## **KITTITAS COUNTY**

### **DEPARTMENT OF PUBLIC WORKS**

**RE:** Wenger Short Plat – Final Plat (SP-07-00007)

I have reviewed the final plat submitted for Wenger Short Plat (SP-07-00007). My comments appear below for your consideration – pending your response to the applicant.

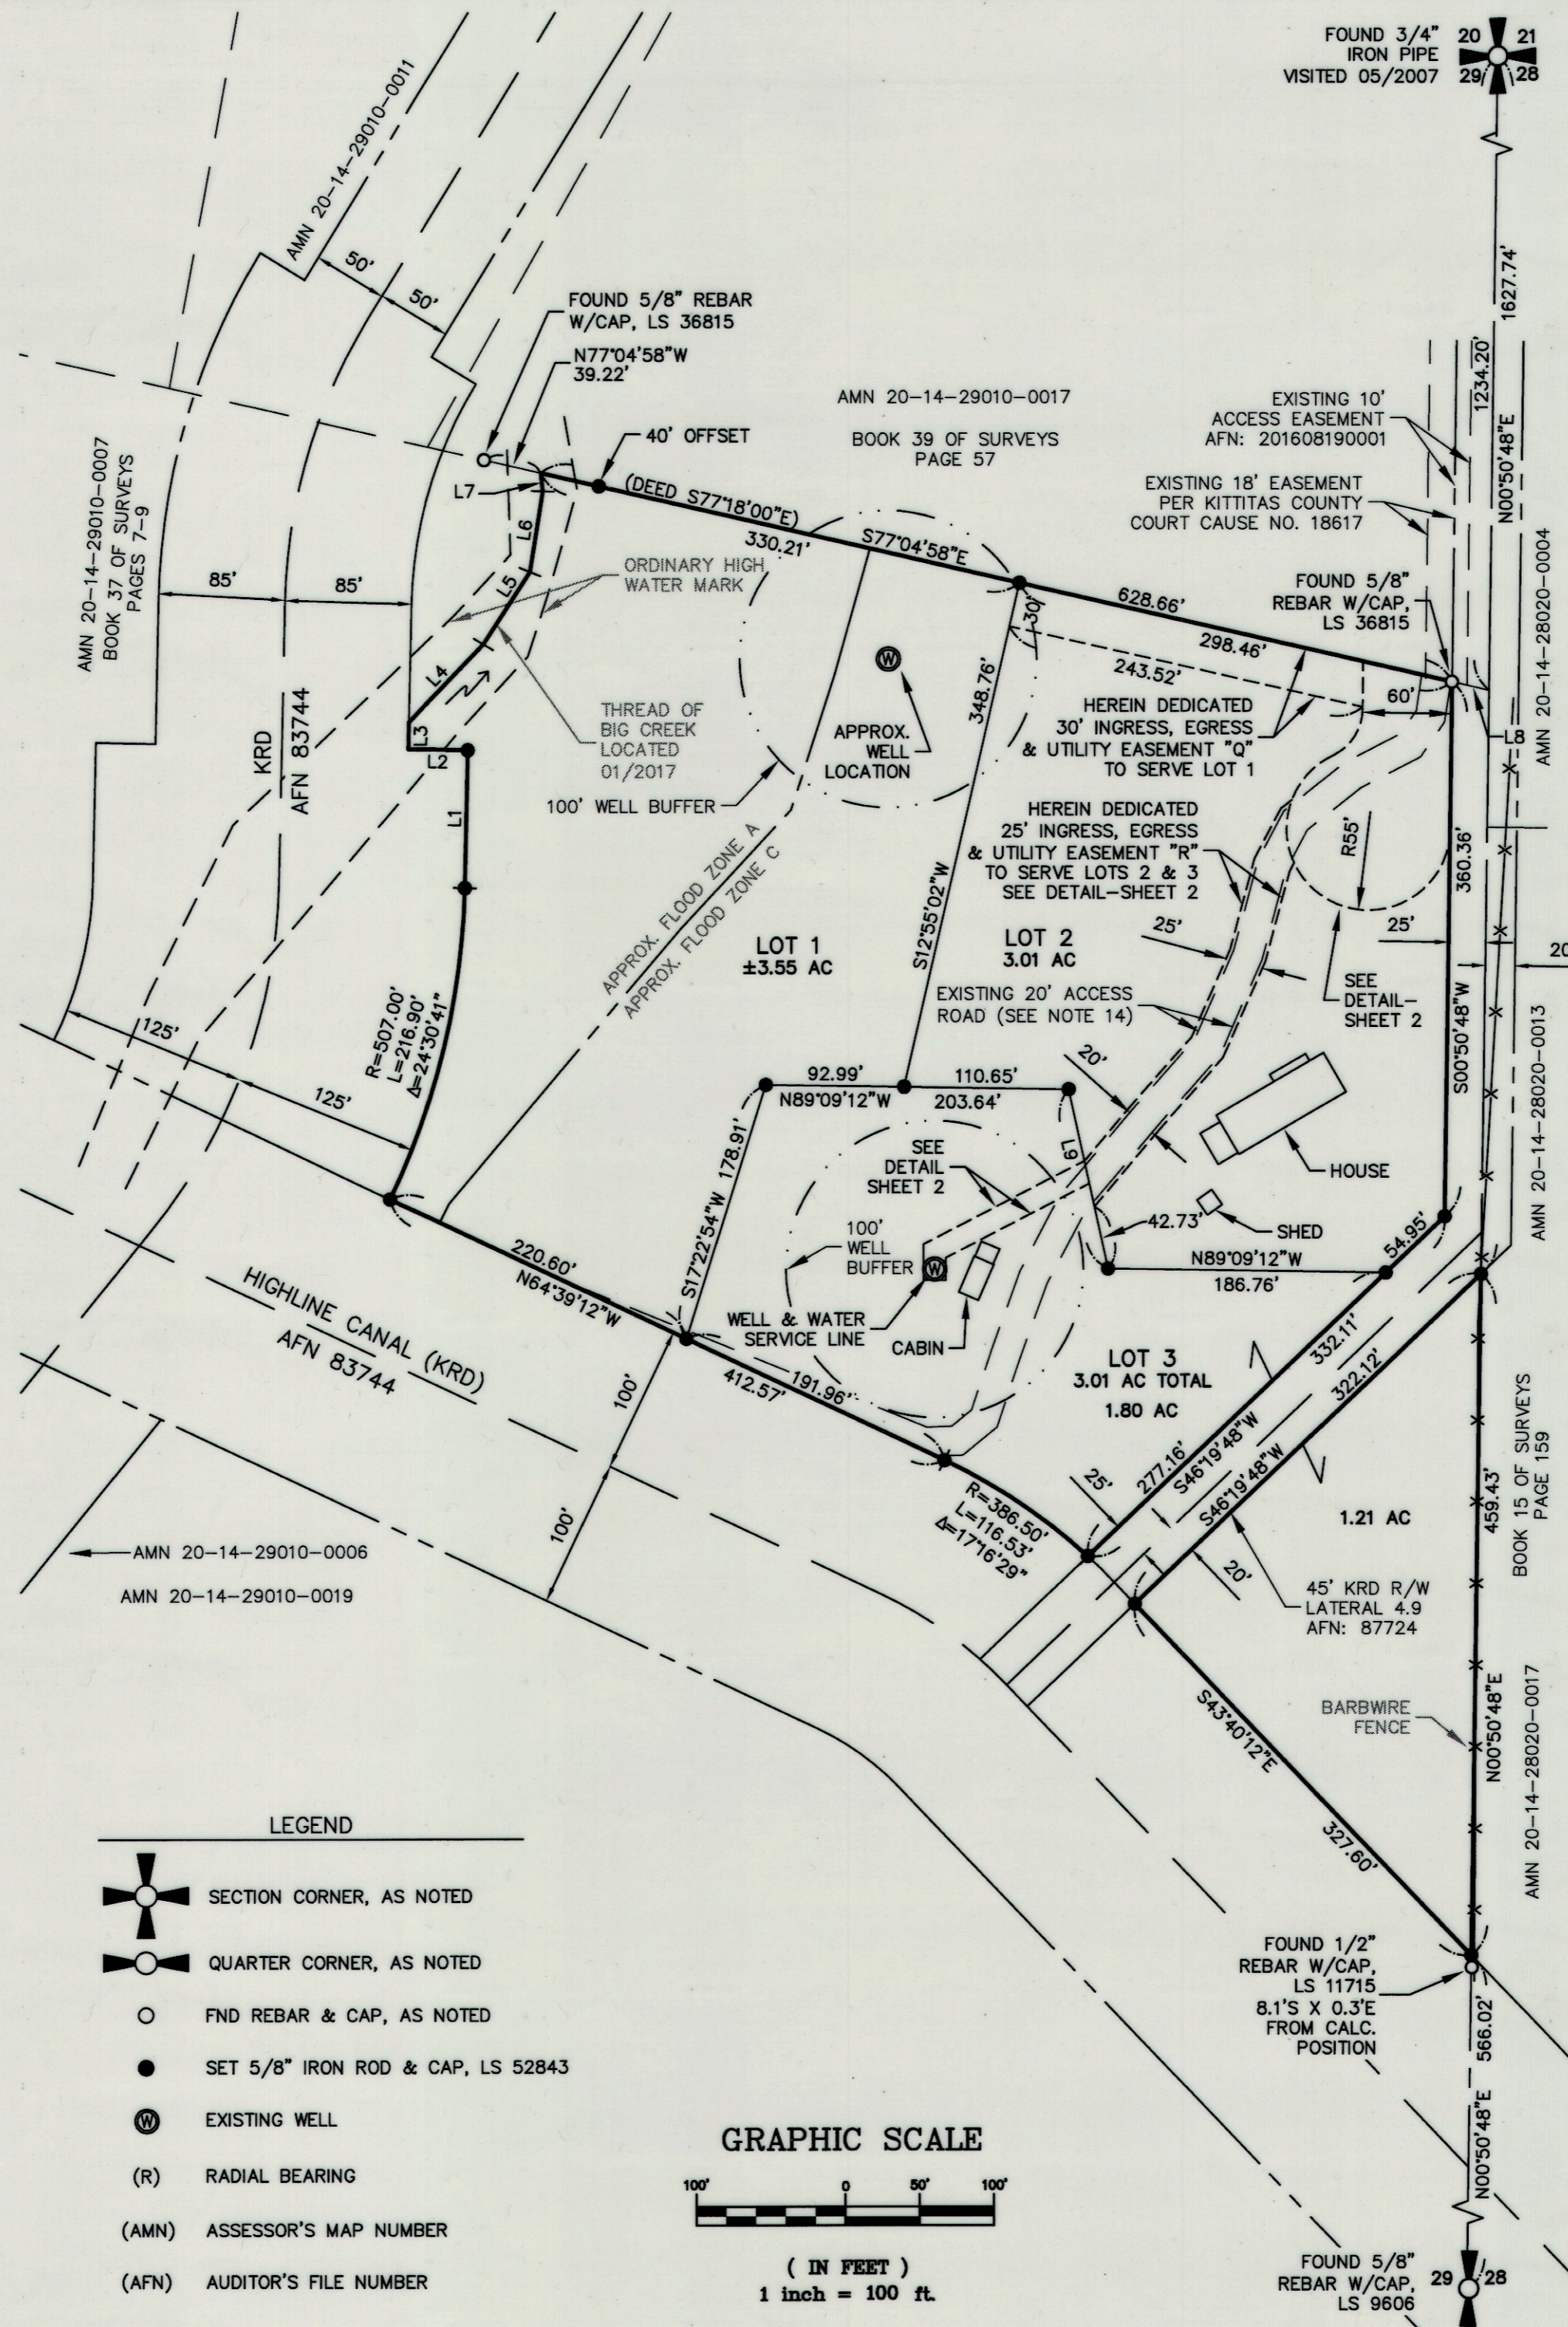
3. Preliminary condition of approval 7(d)(v) requires the access to parcel 616536 be shown on the final plat. That condition is not met on the final plat that I have been provided for review.
